PLANNING CONSULTATION RESPONSE

Application No	<u>2026/0422</u>
Proposal	Residential development of up to 144 units and associated works
Address	Land to the south of Weetshaw Lane Roundabout, Cudworth, Barnsley
Date of Consultation Reply	21/07/26
Consultee	Highways Development Control

Consultation Assessment and Justification

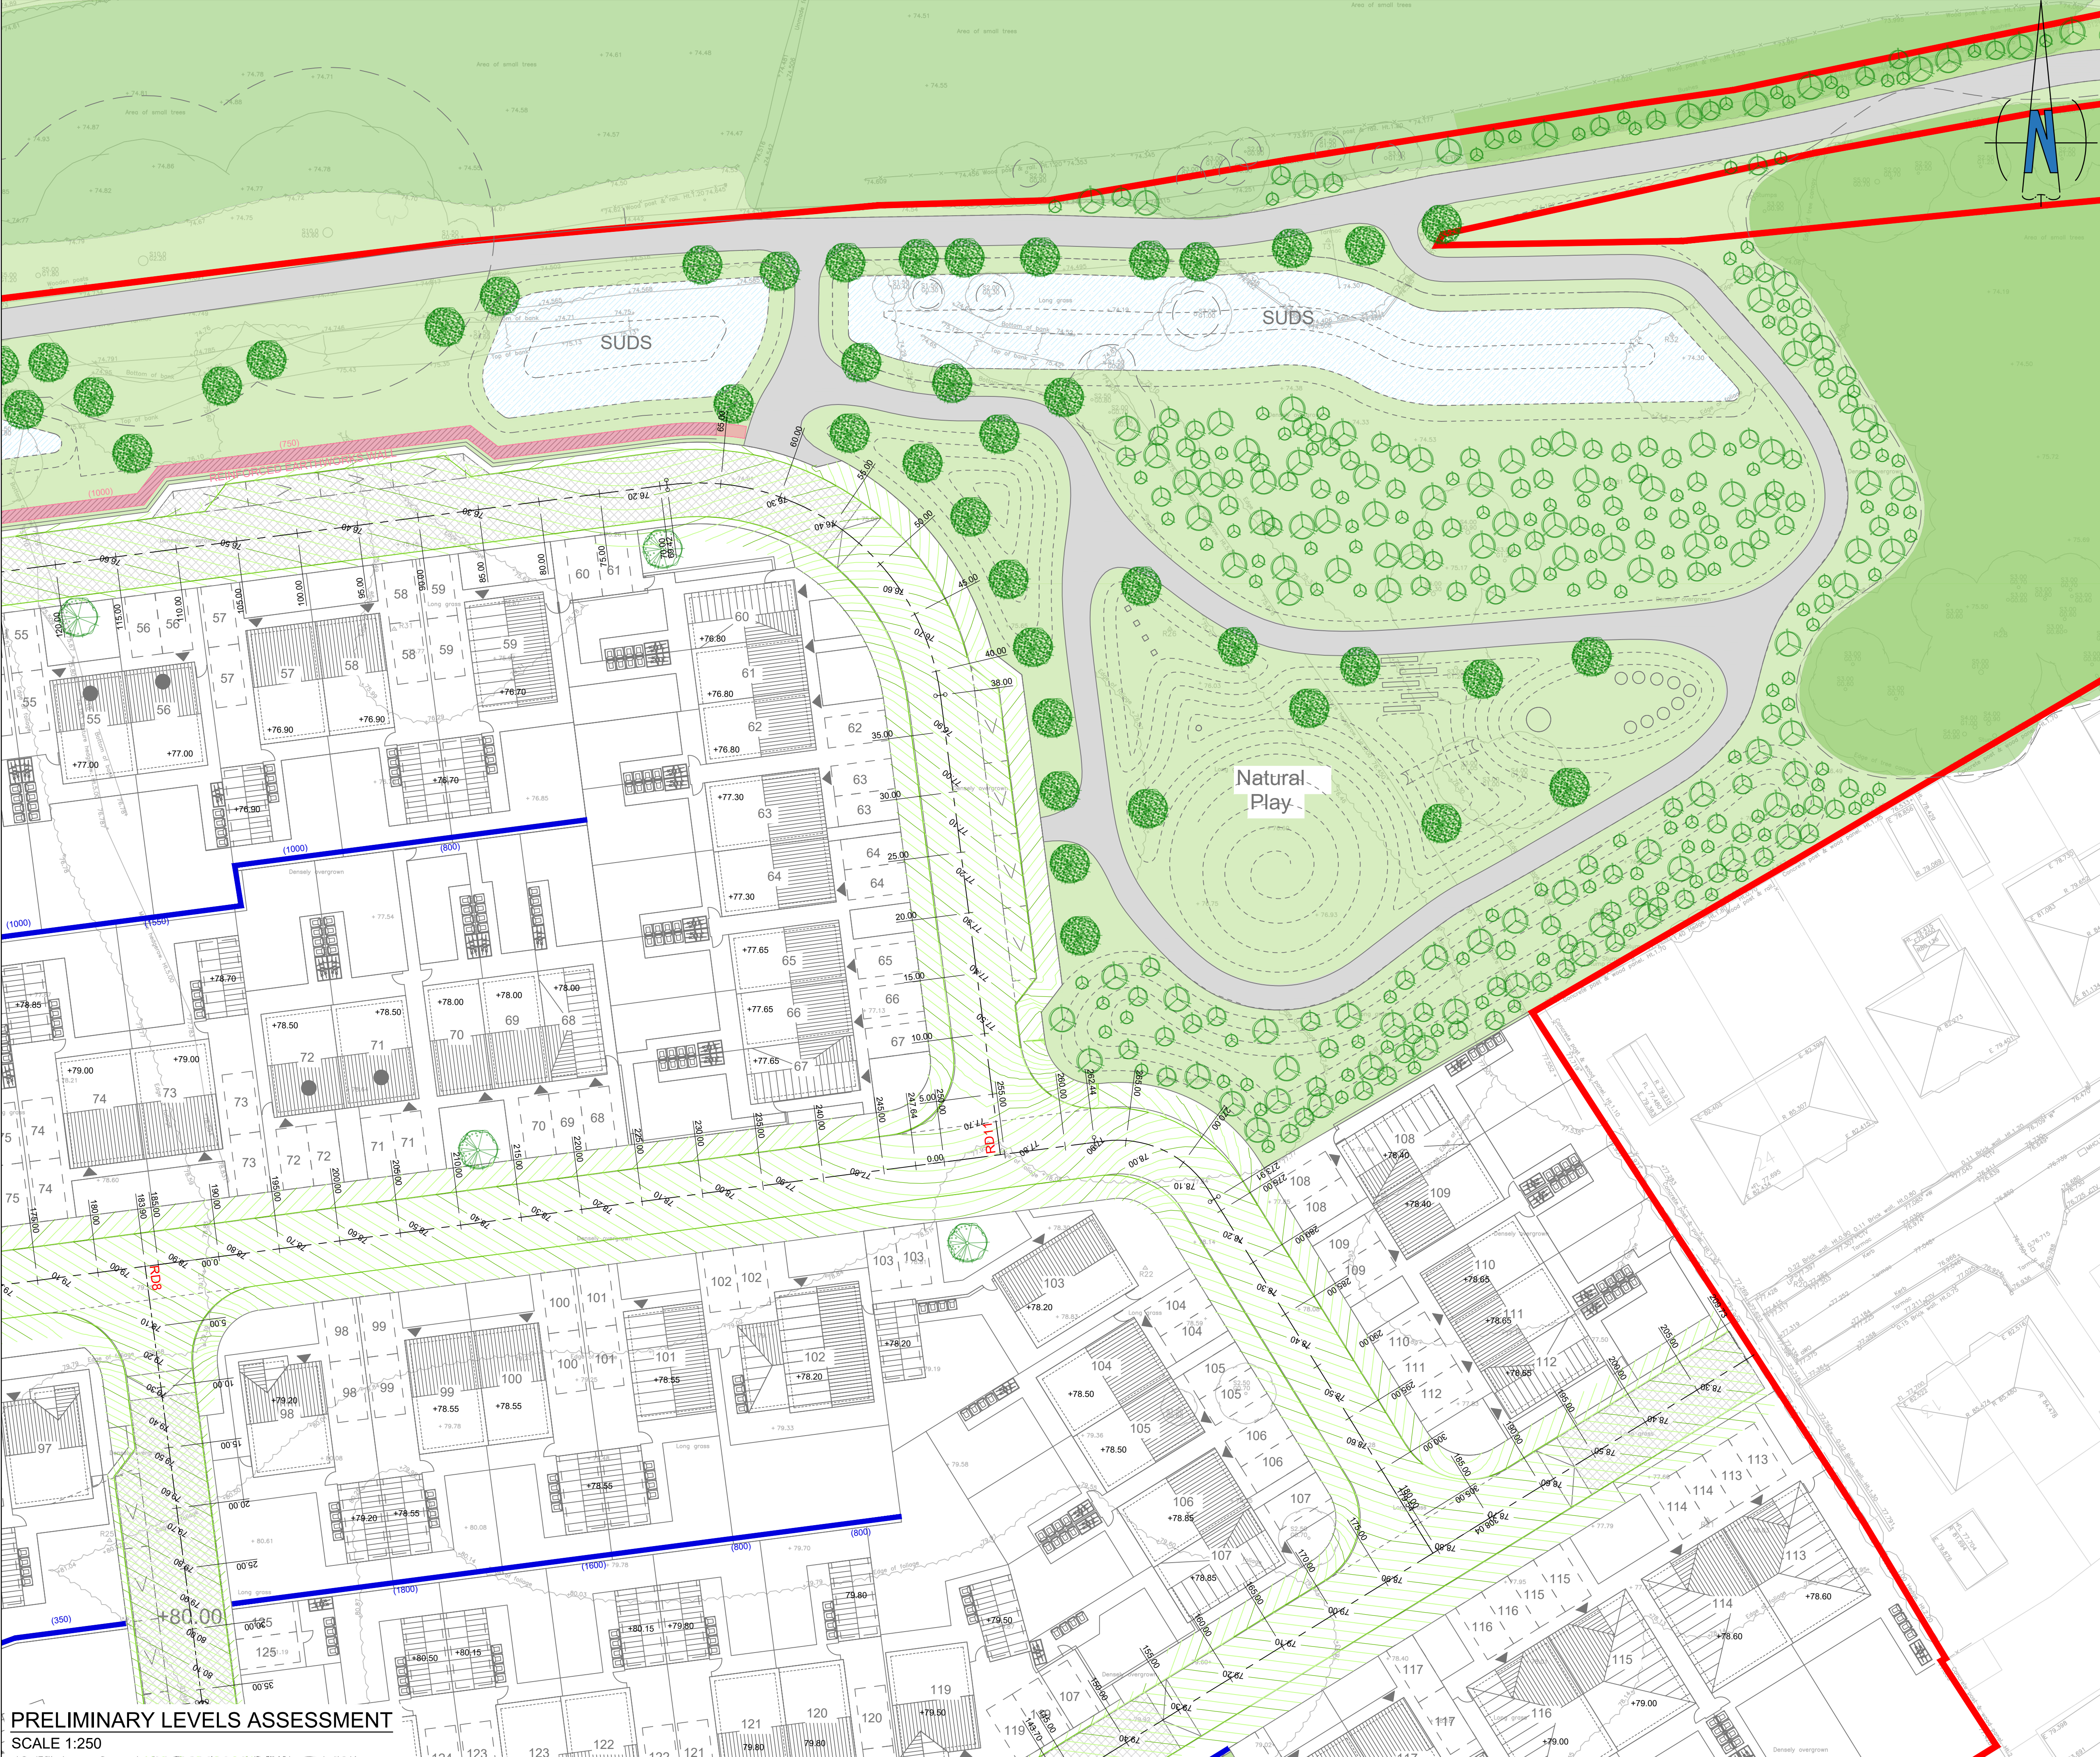
The site has a significant change in level from south to north and northeast and note that site sections have been provided, I have forwarded these plans to our s38/278 engineers and

should any further comments arise in relation to this, I will forward these on once received. Given the level differences with the site, consideration should be given to the accessibility of the walking routes connecting the higher parts of the site with Three Nooks Lane, the bus stops and the proposed public open space.
